2024/0225

Address: 12 Thruxton Close, Cudworth, Barnsley, S72 8NB

Description: Single storey side extension to 2 storey semi-detached dwelling

PROPOSED ELEVATIONS

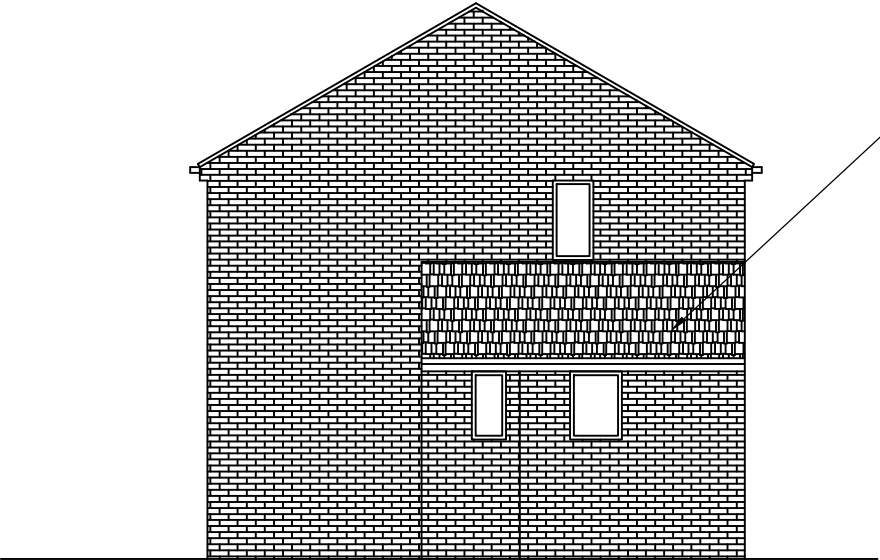
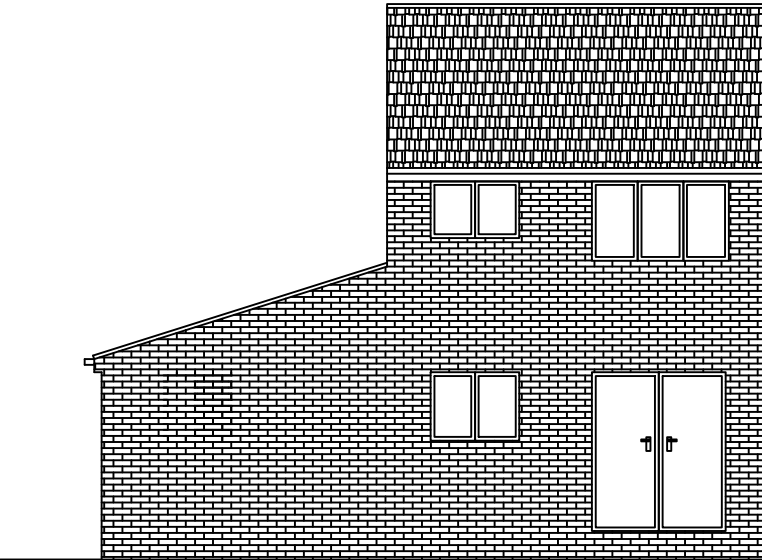
The proposal is for a modest sized side extension, attached to an existing protrusion or permitted development extension. The proposal would include alterations to or a new roof of a similar design, but which would be slightly higher and cover the existing ground floor extension, and the proposed extension. Unusually glazed sliding doors would be located on the front of the proposed side extension, in replacement of an existing single door.

Whilst in principle, the proposed extension itself would not have any significant impact on the character of the dwelling or the visual amenity of neighbouring dwellings, due to its size, location and distance to other dwellings. The proposed sliding doors are an unusual choice and may have a small impact on the character of the dwelling. In mitigation of this, the principal front door is to remain on the front elevation, with the glazed doors set almost 3m back from the front elevation. Regarding the impact on the street scene, overall due to the location of the extension and the distance between the dwelling and the road, the extension's impact would only be minimal and would not significantly harm the broader street scene.
